From: Paul Cann
Sent: 27 September 2017 16:08
To: Planning.Responses
Subject: RE: Planning Consultation on: A/154/17/PL

Engineers comments in respect to surface water drainage:

APPLICATION **A/154/17/PL**

Description of Works: Erection of industrial building (Unit 35b) for B1 (Business)/B8 (Storage or Distribution) purposes, relocation of existing site managers office & workshop. This application is a Departure from the Development Plan.

drawing No: **17029-A-PL02S** revision: **A**

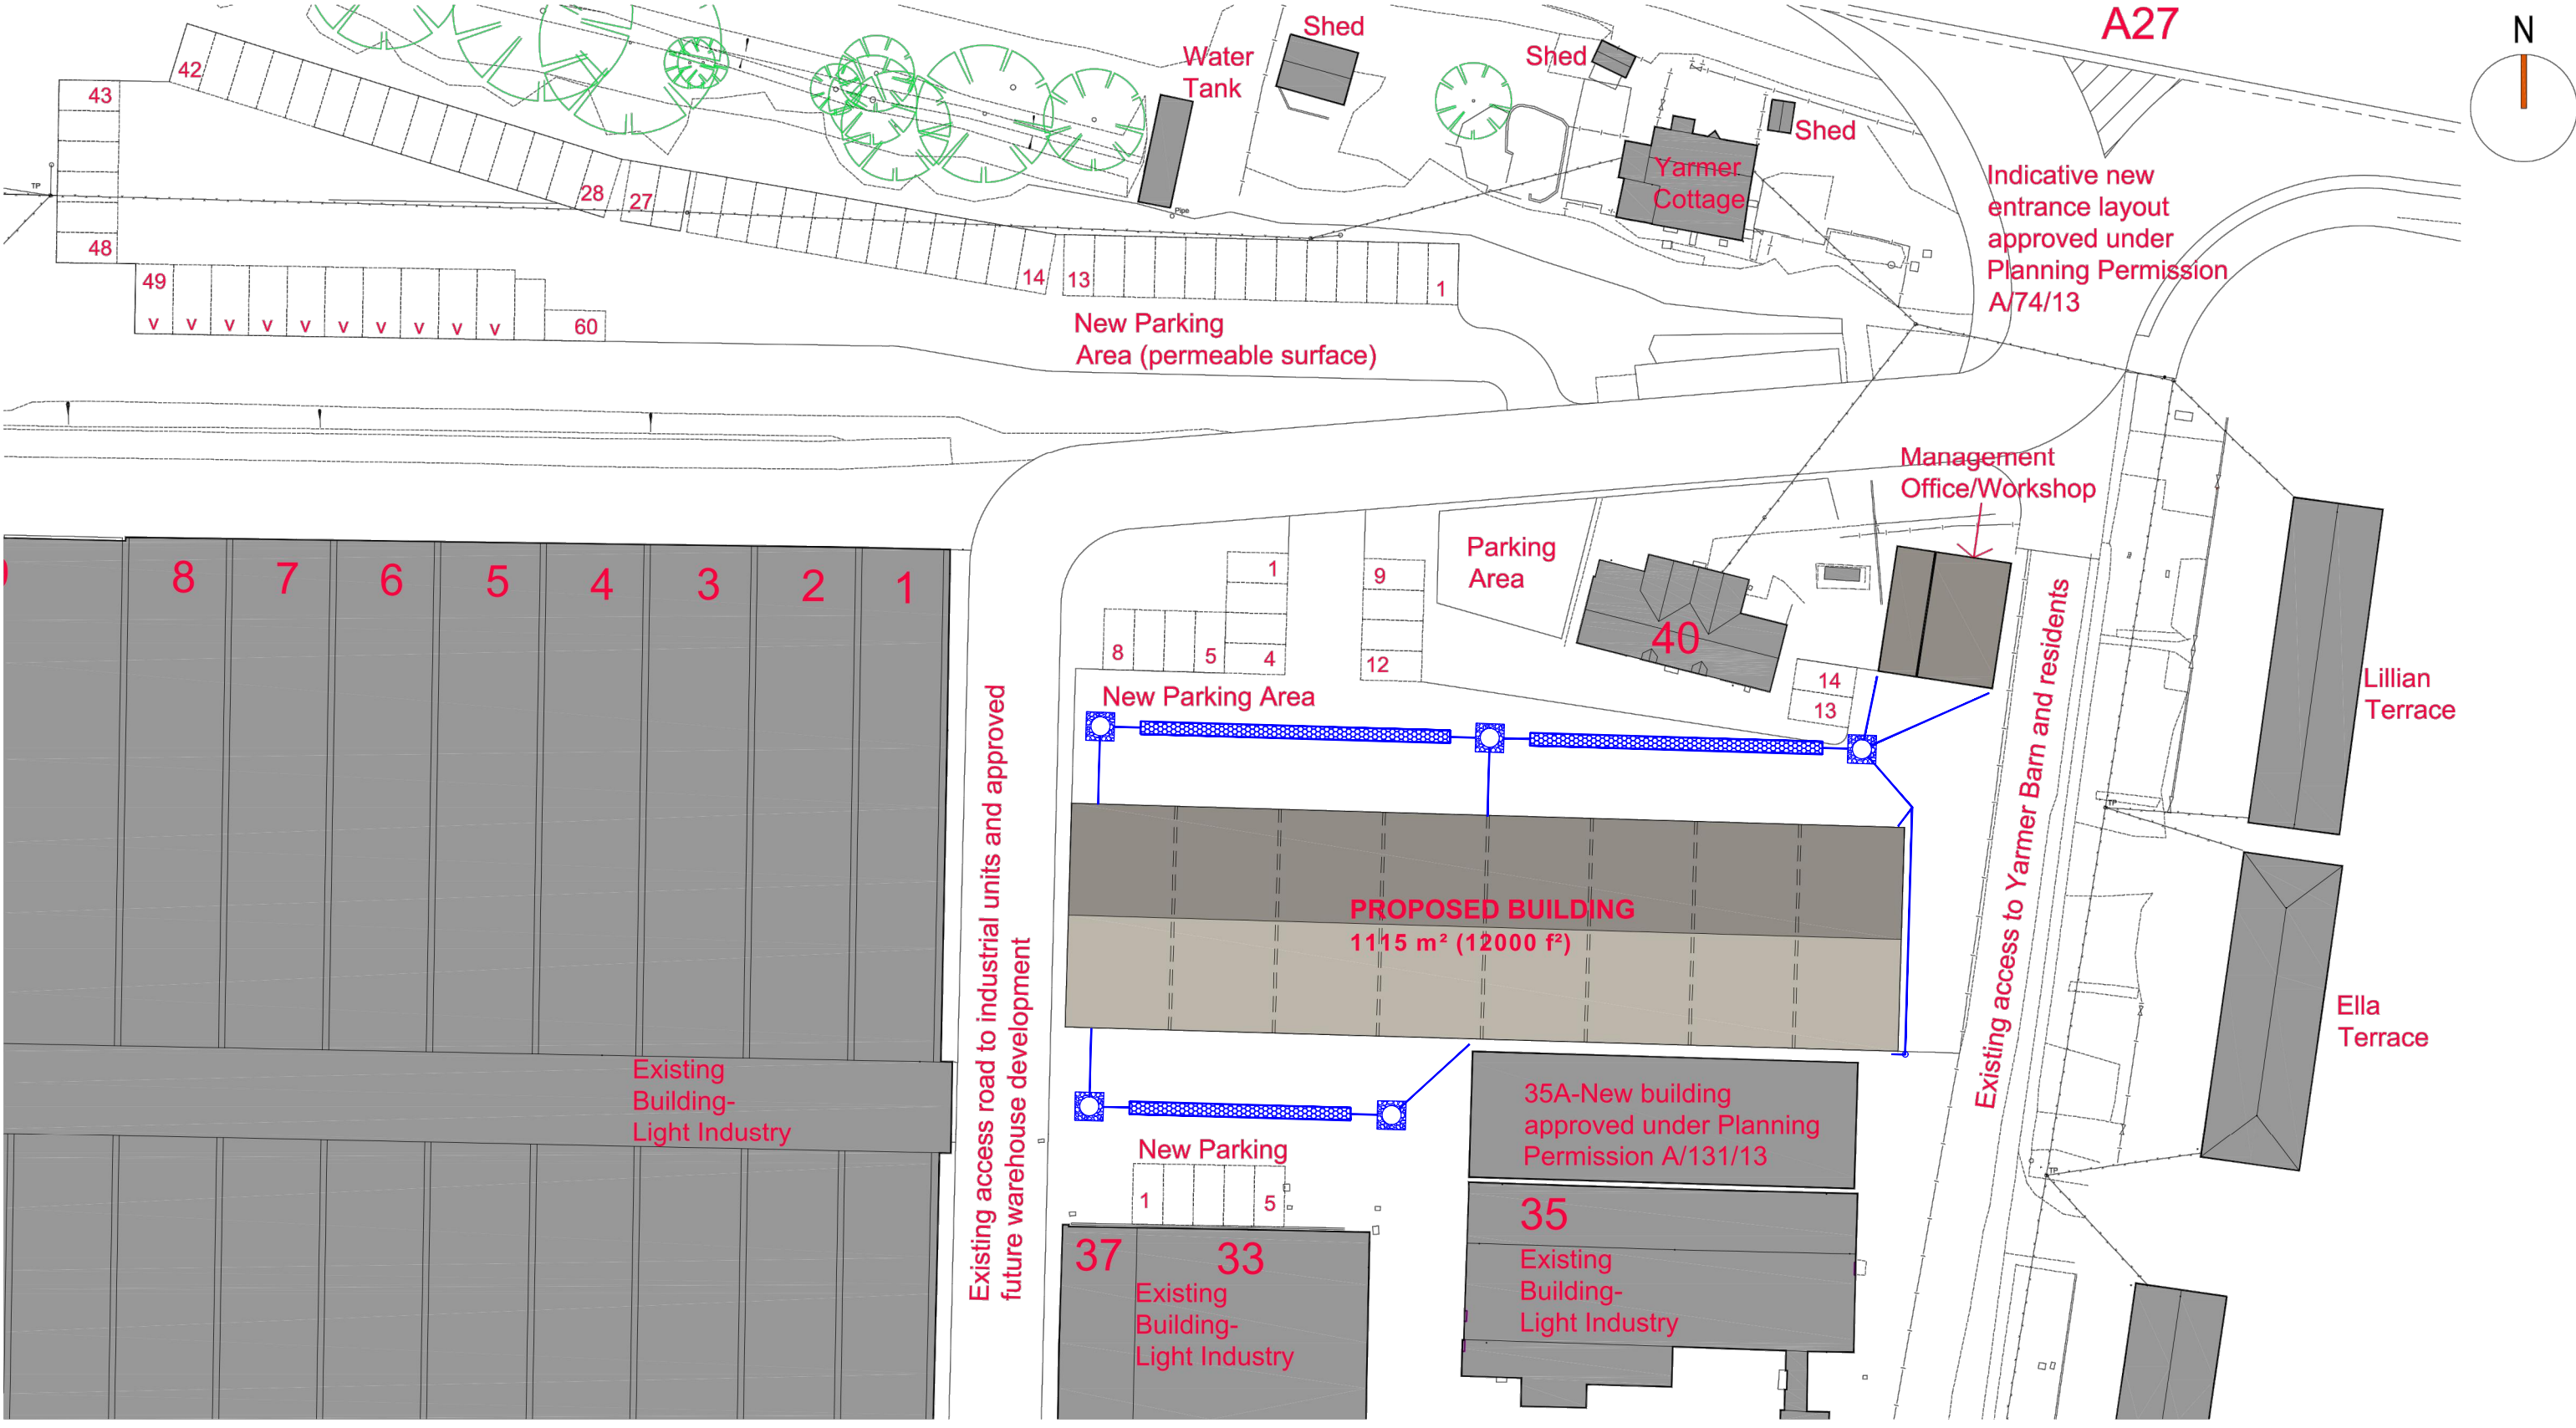
Soakaways must be fully investigated for surface water disposal.

Infiltration rates for soakage structures are to be based on percolation tests undertaken in the winter period and at the location and depth of the proposed structures. The percolation tests must be carried out in accordance with BRE 365, CIRIA R156 or a similar approved method and cater for the 1 in 10 year storm between the invert of the entry pipe to the soakaway, and the base of the structure. It must also have provision to ensure that there is capacity in the system to contain below ground level the 1 in 100 year event plus 30% on stored volumes, as an allowance for climate change. Adequate freeboard must be provided between the base of the soakaway structure and the highest recorded annual groundwater level identified in that location.

Any SuDS or soakaway design must include adequate groundwater monitoring data to determine the highest winter groundwater table in support of the design. It is noted that some groundwater monitoring and percolation testing was carried out in October 2015 but further investigations will be required during the winter to confirm peak groundwater levels/worst case percolation rates. The applicant should contact us at the relevant time to agree when the further testing is to be carried out.

Following the further investigations, we will require a detailed design with supporting hydraulic calculations, together with relevant construction details.
